To the Examiner Stuart Cowperthwaite

Friends of Markeaton Park submission deadline 15 25th June 2020. Response to Highways England REP14 039

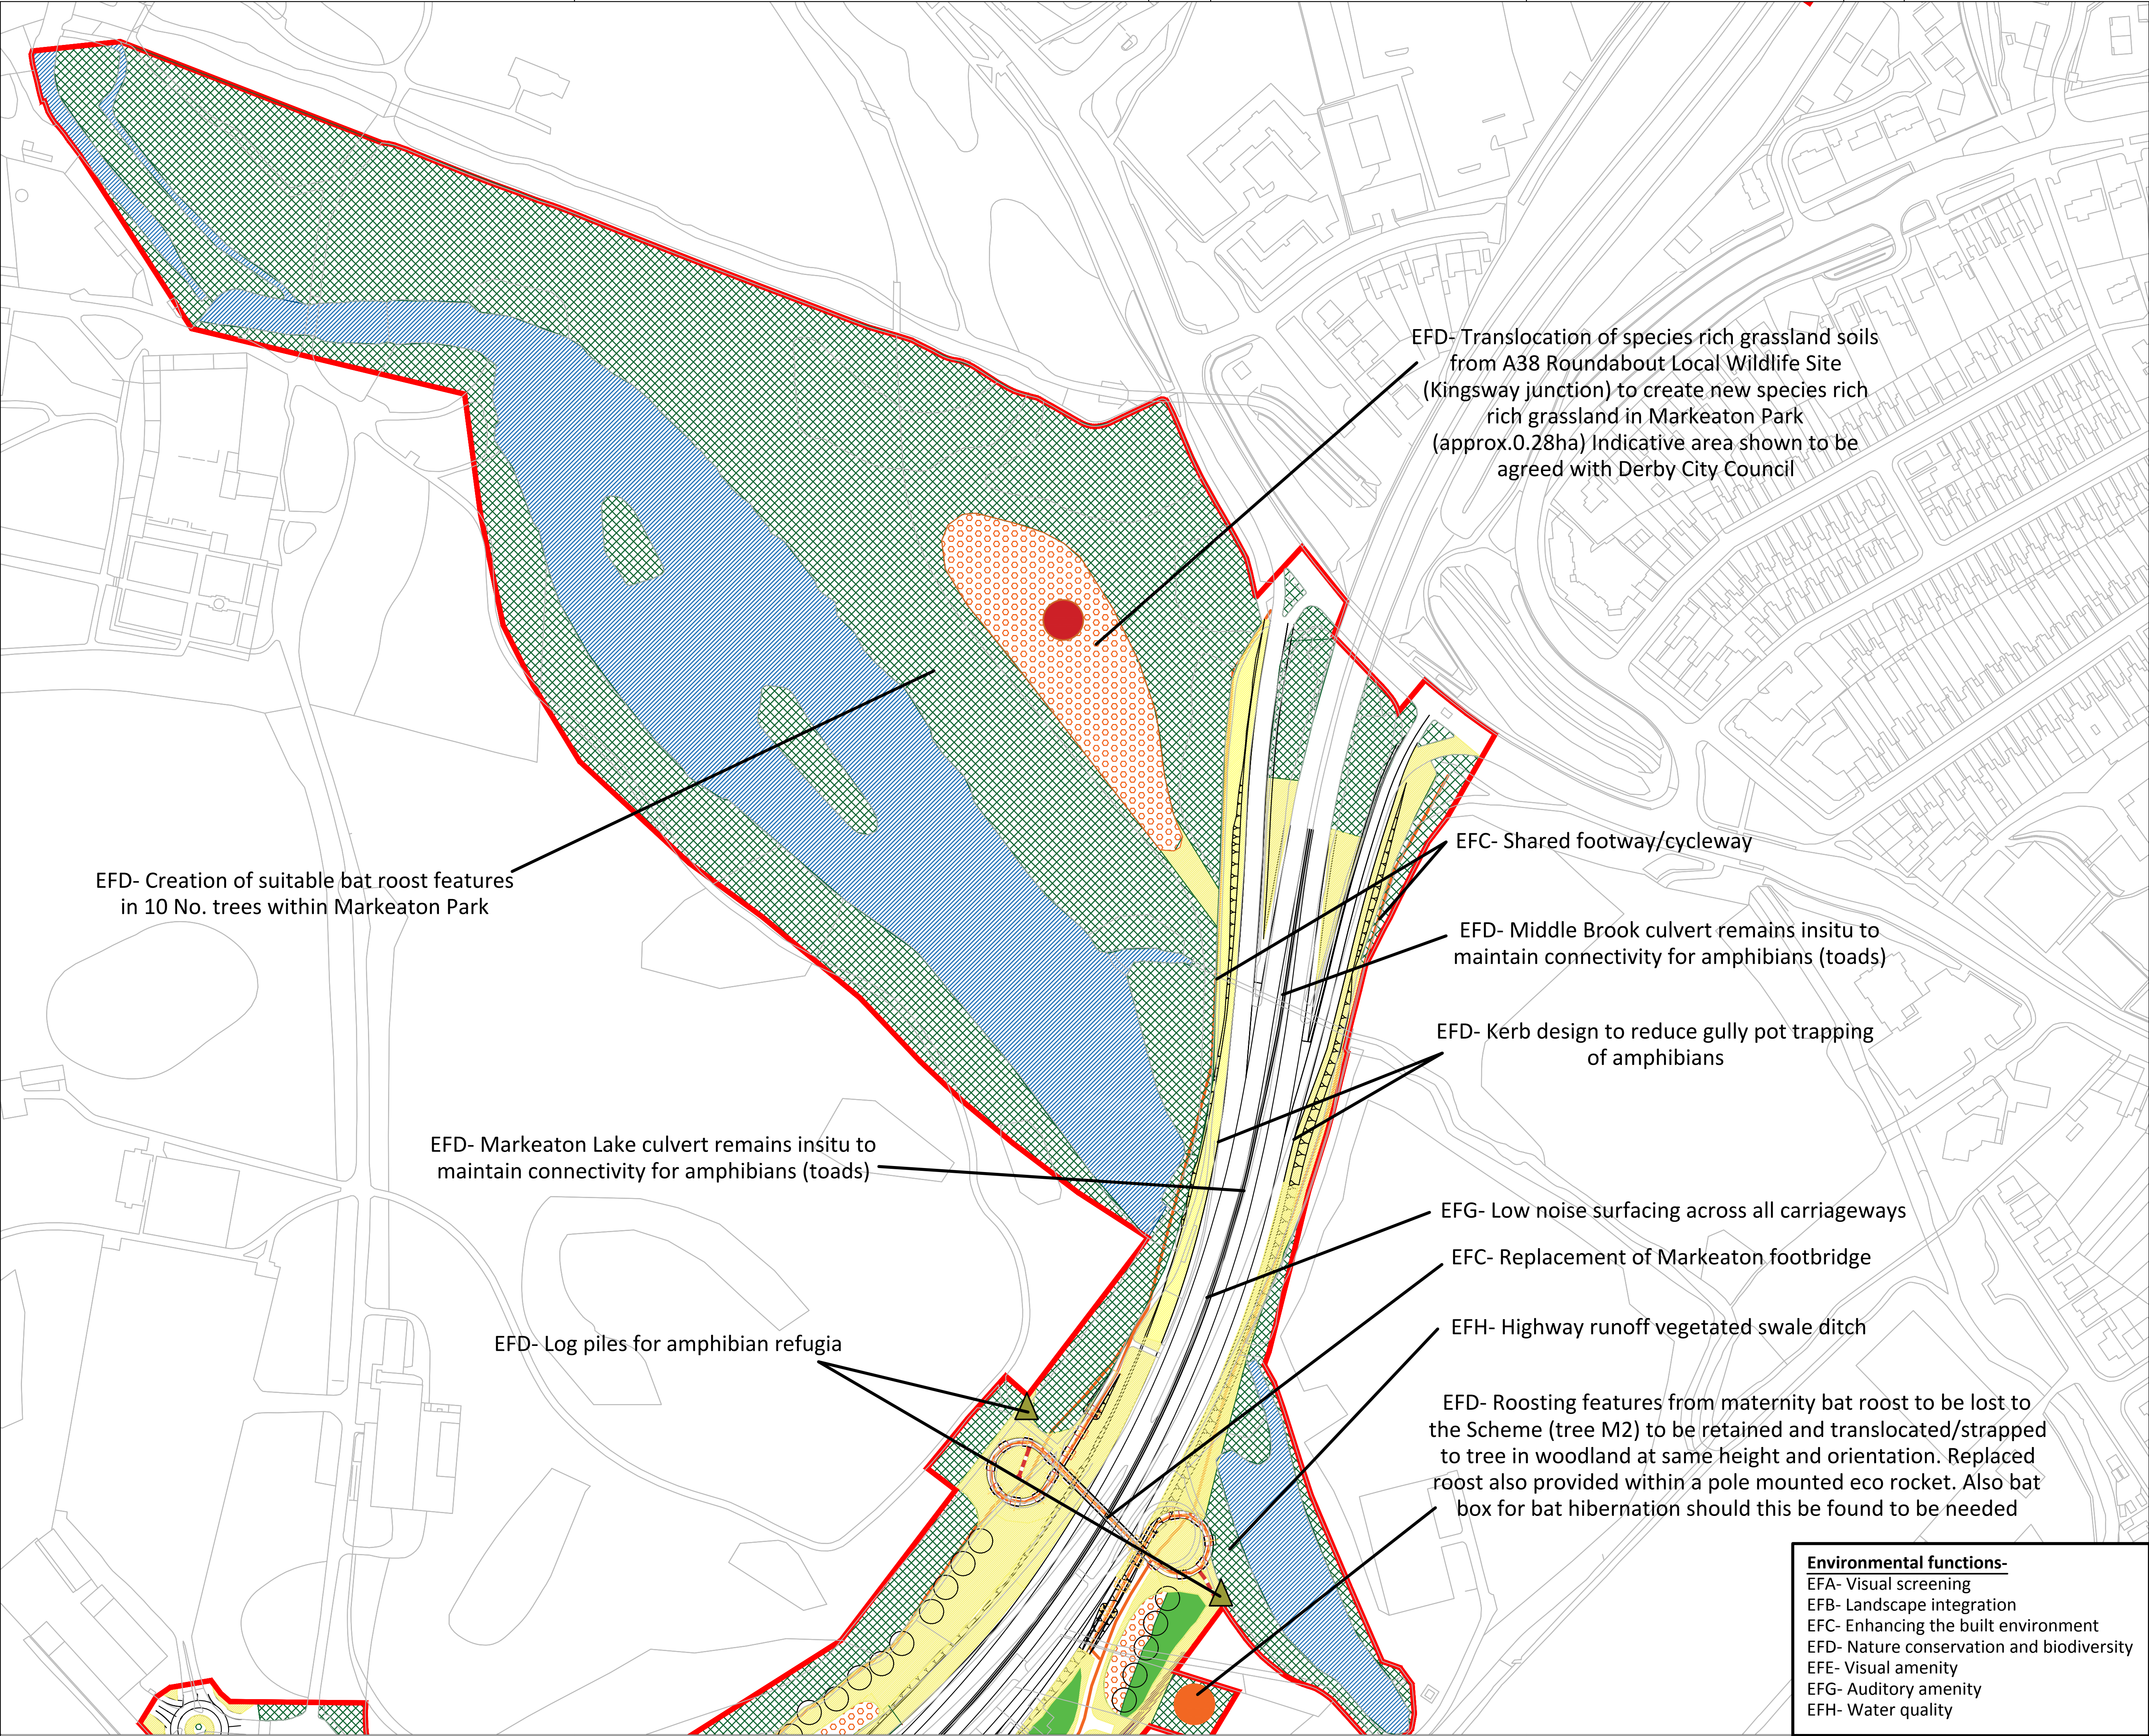
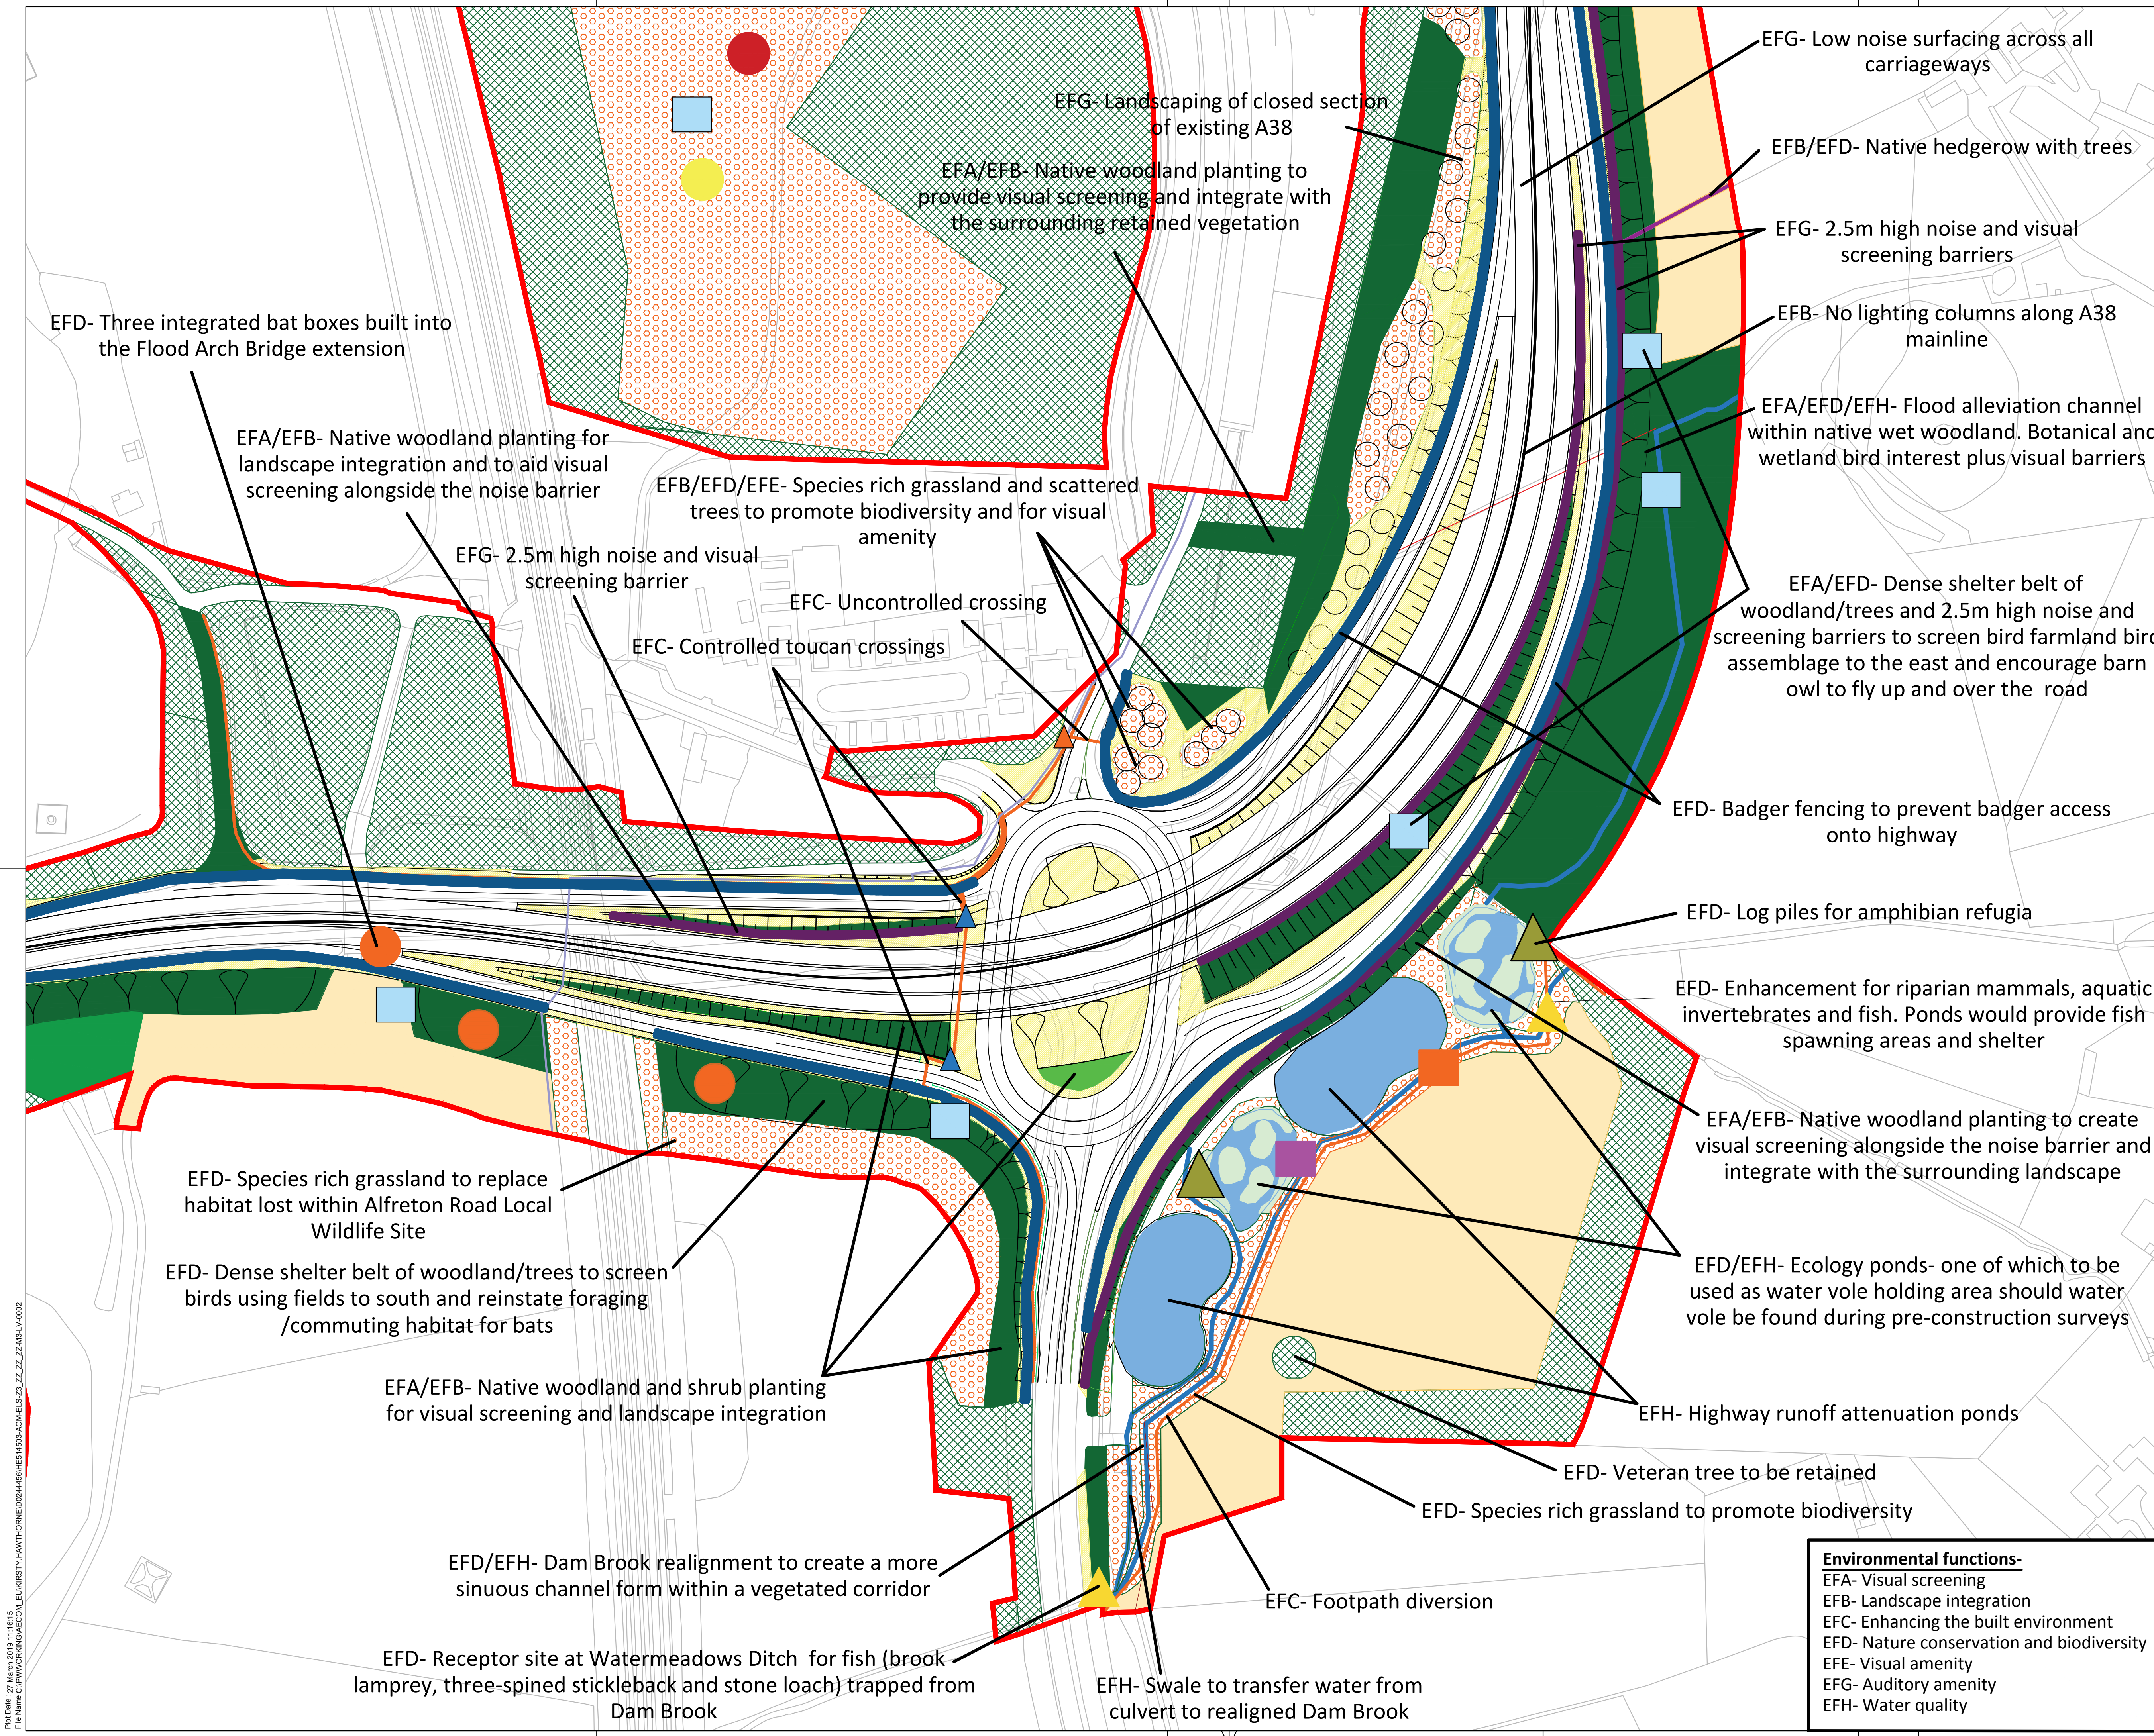
Tree planting plus Bat Totem poles in the same place.

EPO describes the dumping of unwanted soil excavated from above a capped landfill site (possibly contaminated with gases) as “Translocation from roundabout A38 Wildlife Site” That description is not justified. There is no attempt to place wet soil adjacent to Bramble Brook next to any water, nor any attempt to bring the plants that were the reason the site was designated as A38 Kingsway roundabout DE010 Wildlife Site.
